25 February 2022

BOWMANS CREEK WIND FARM (SSD-10315)

This letter has been prepared to provide further information and respond to recommendations, as requested by DPE, Heritage NSW and BCD.

**FIGURE 9**

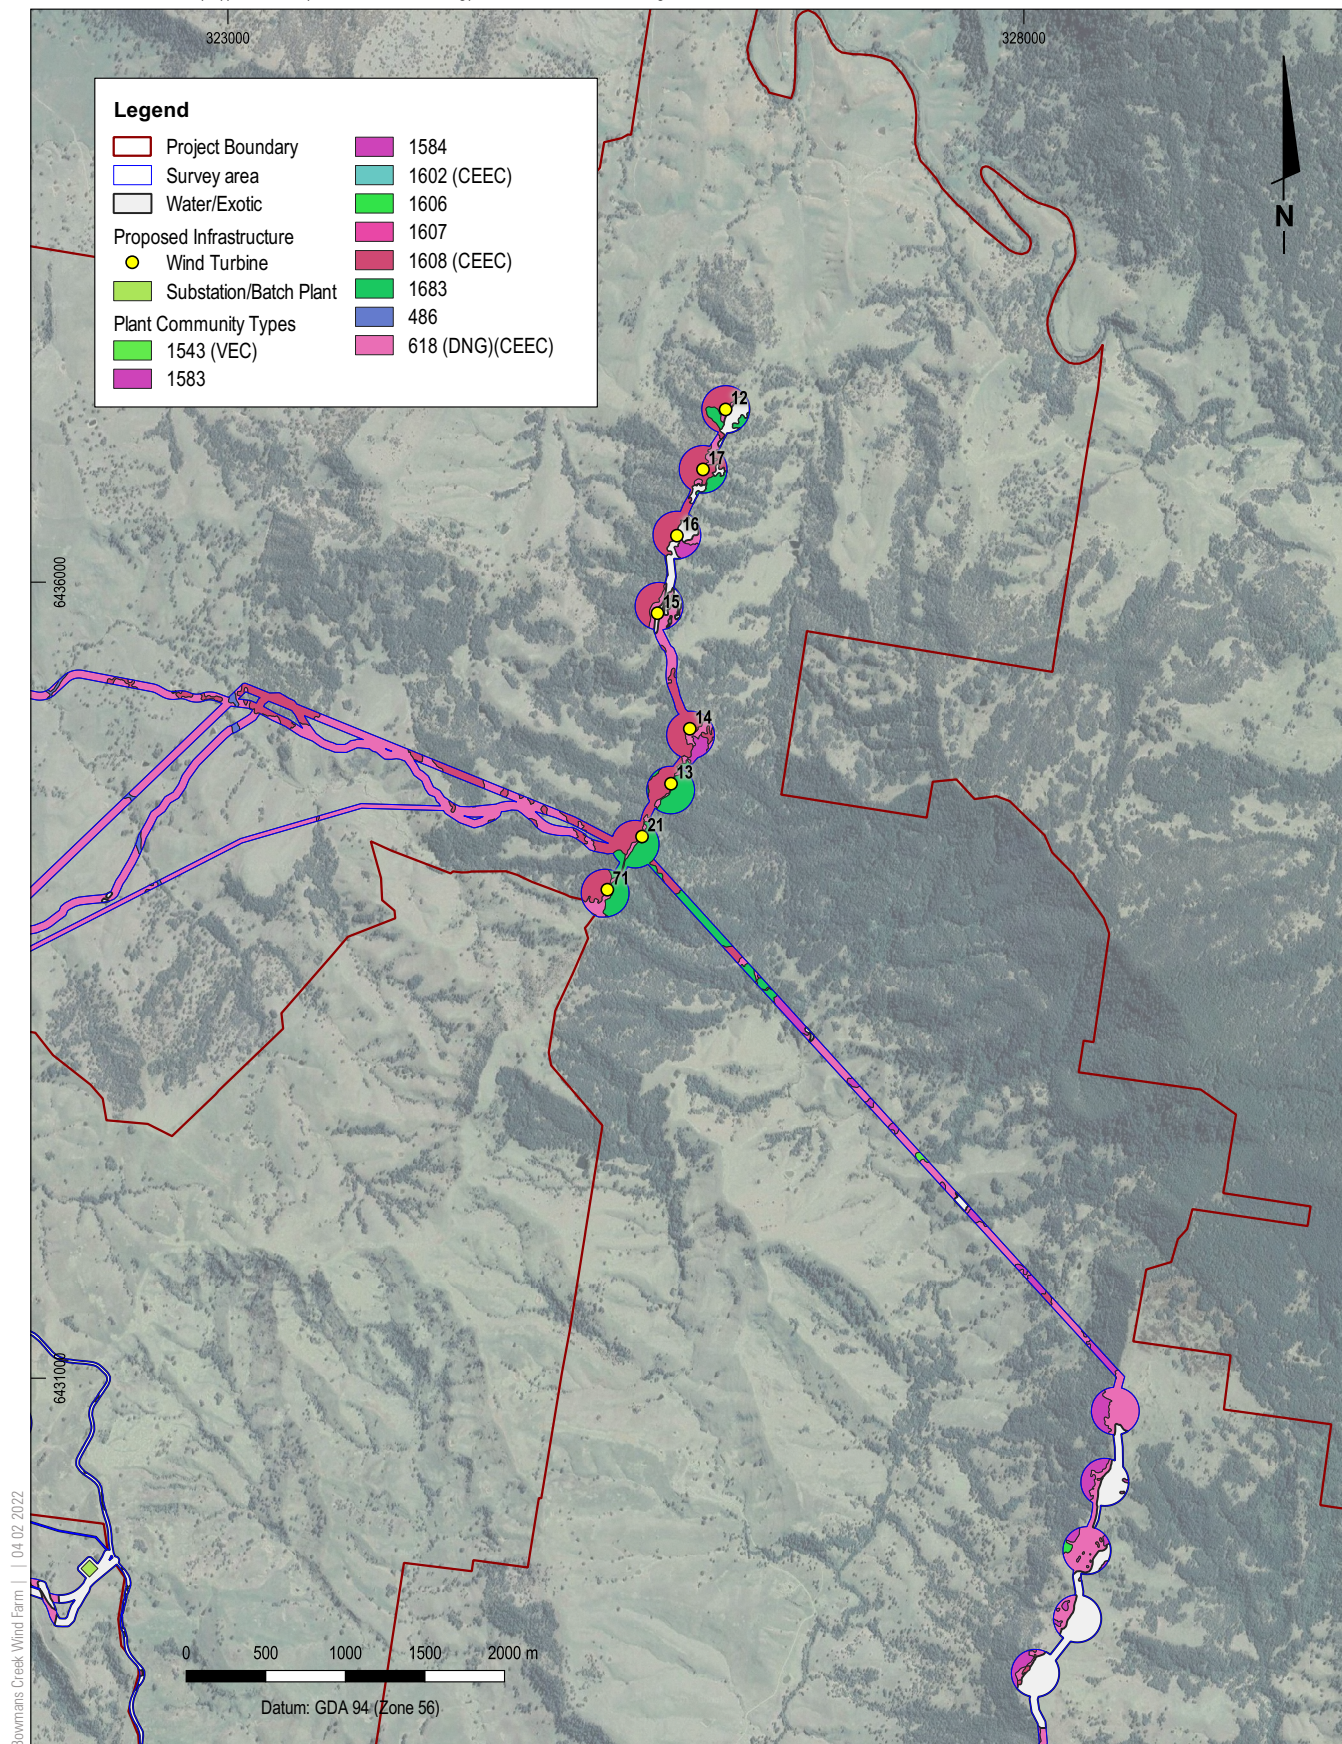
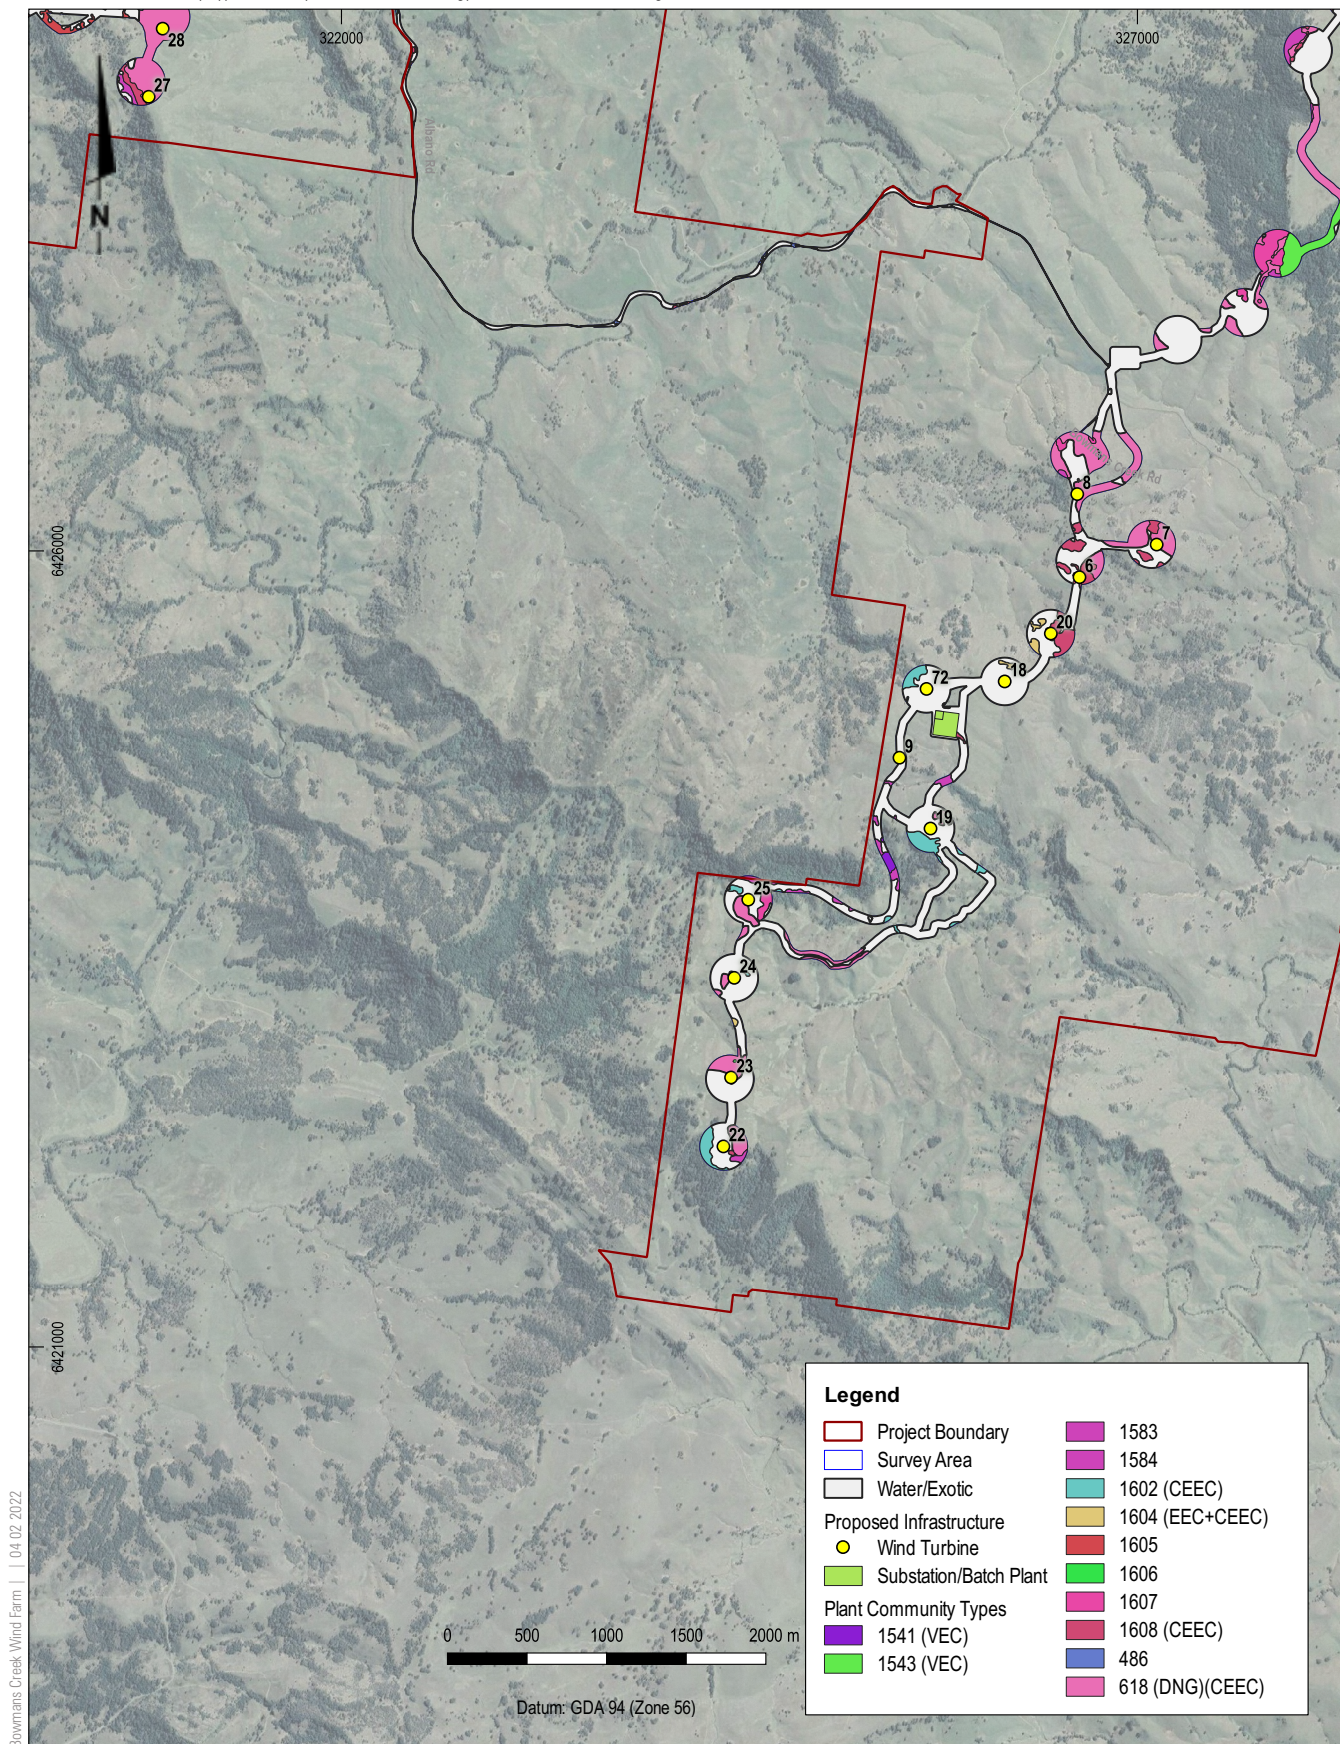
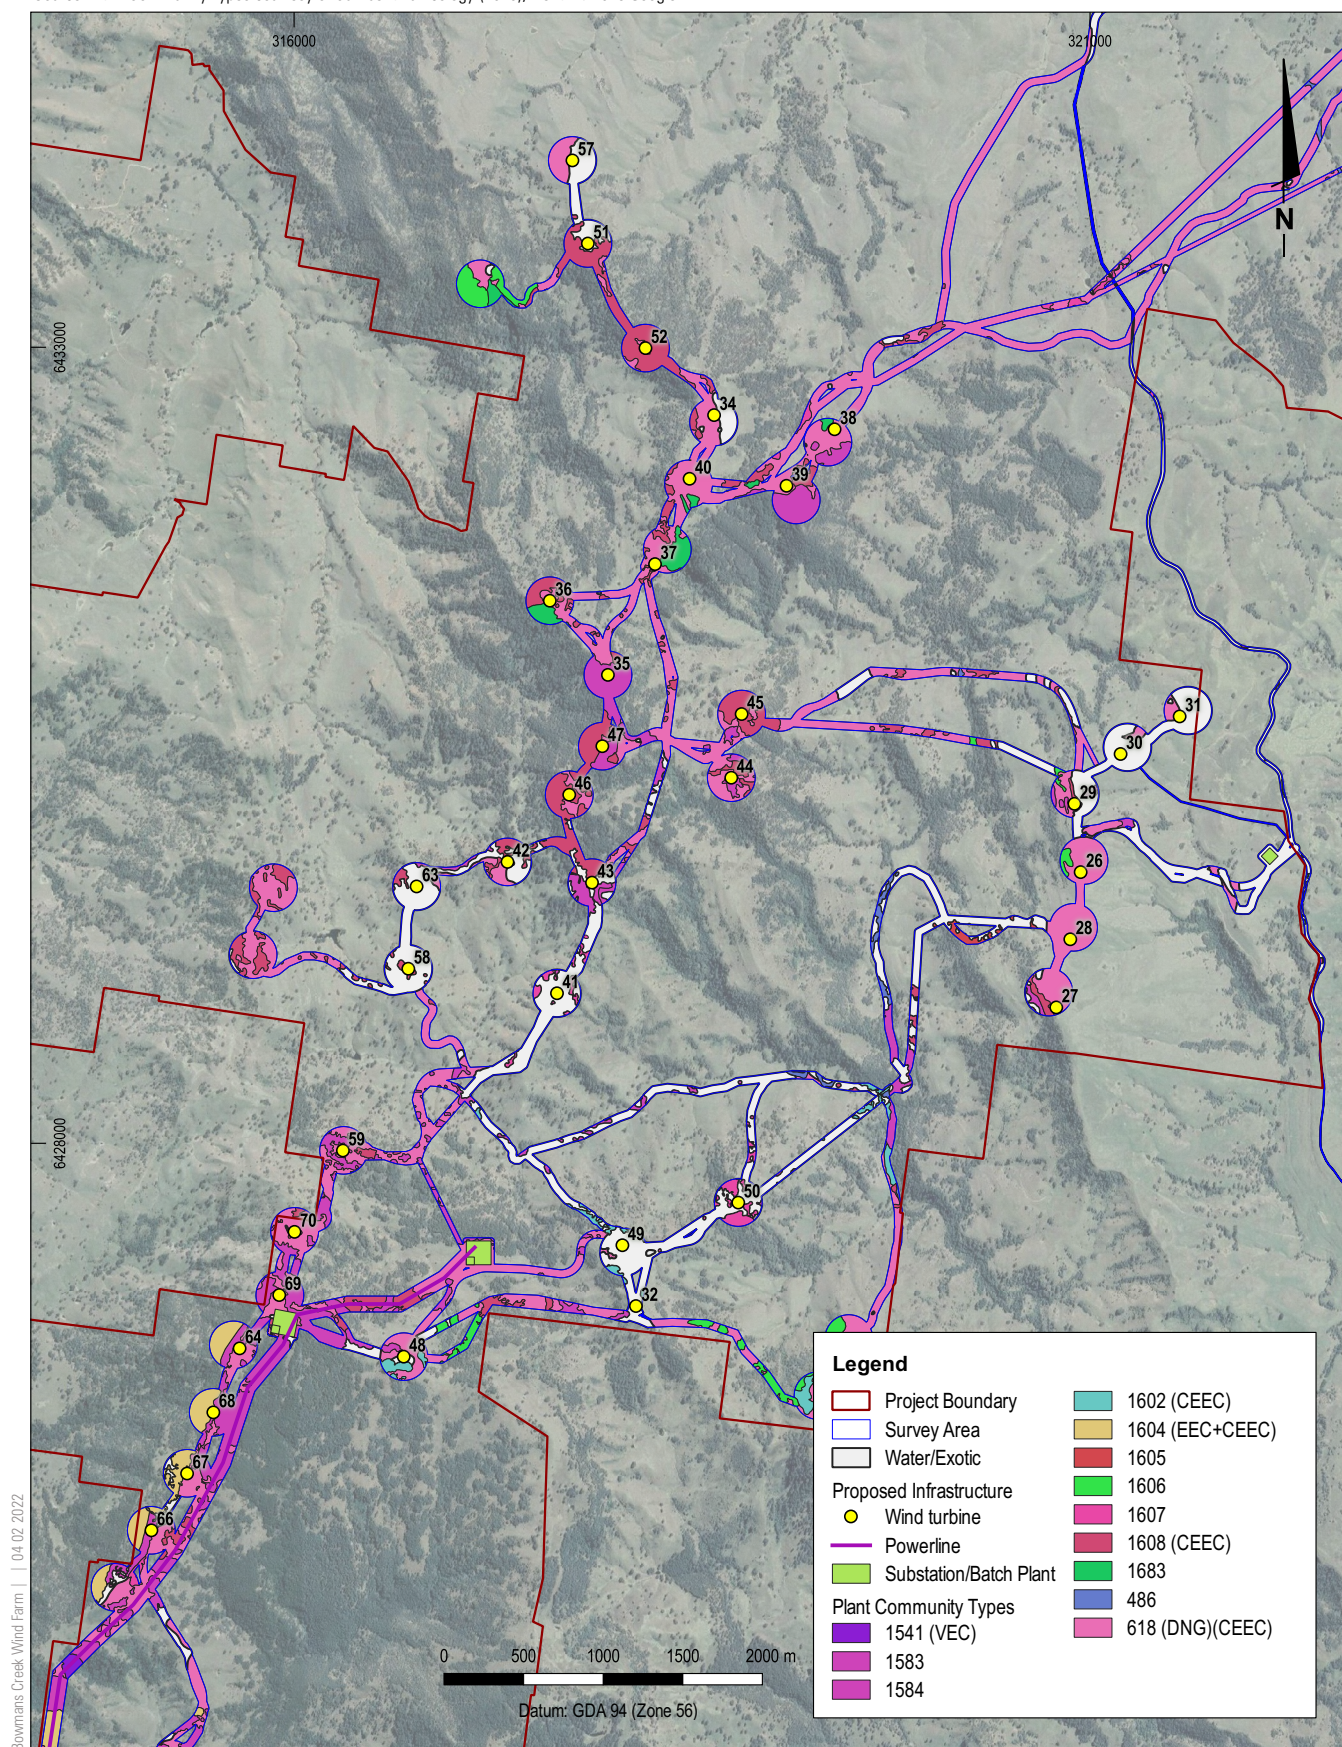
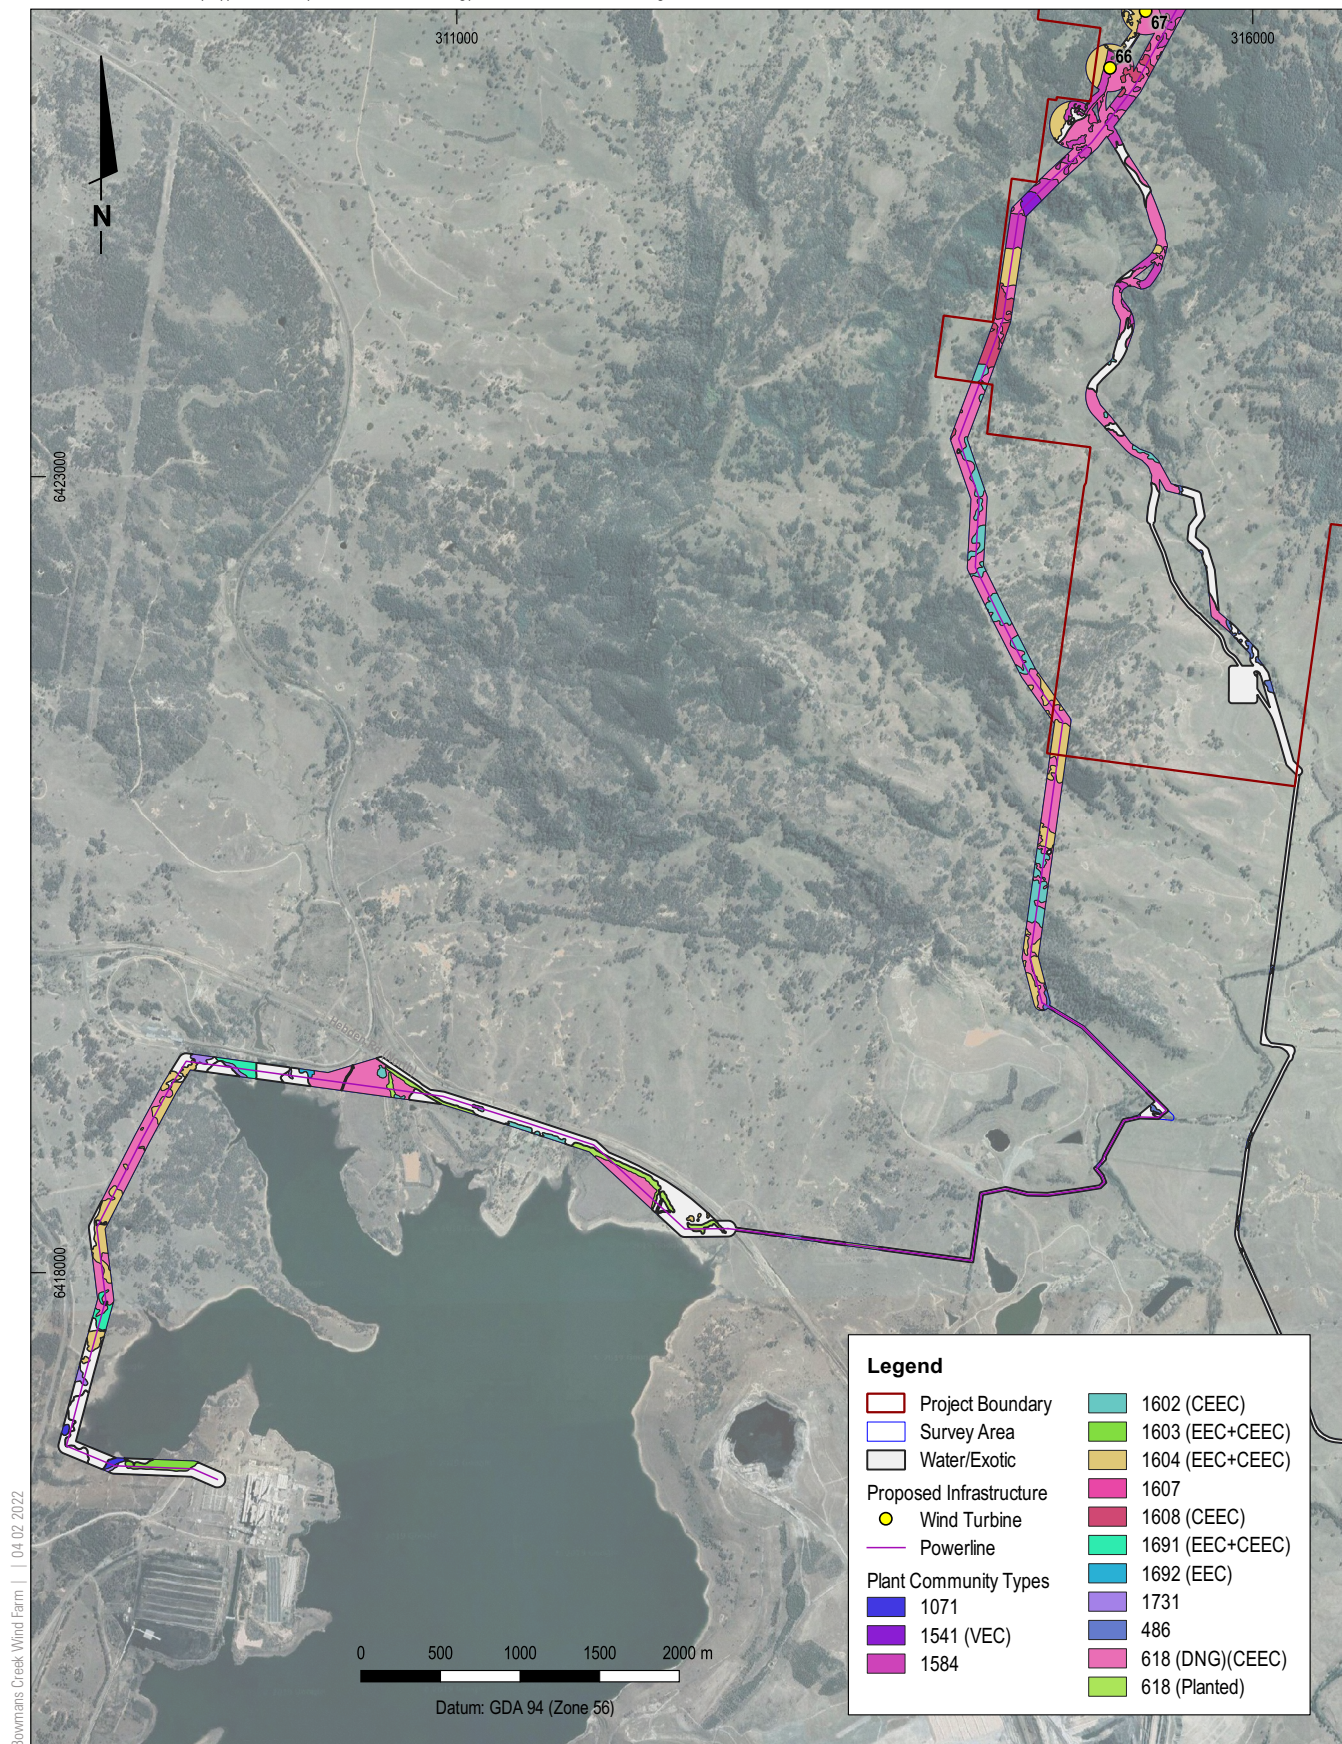
- An updated version of Figures 9 to 13 of the Amendment Report that shows the amended development footprint and identifies the turbines and key infrastructure was requested by DPE.

Updated Figures 9 to 13 are provided in **Appendix E**.
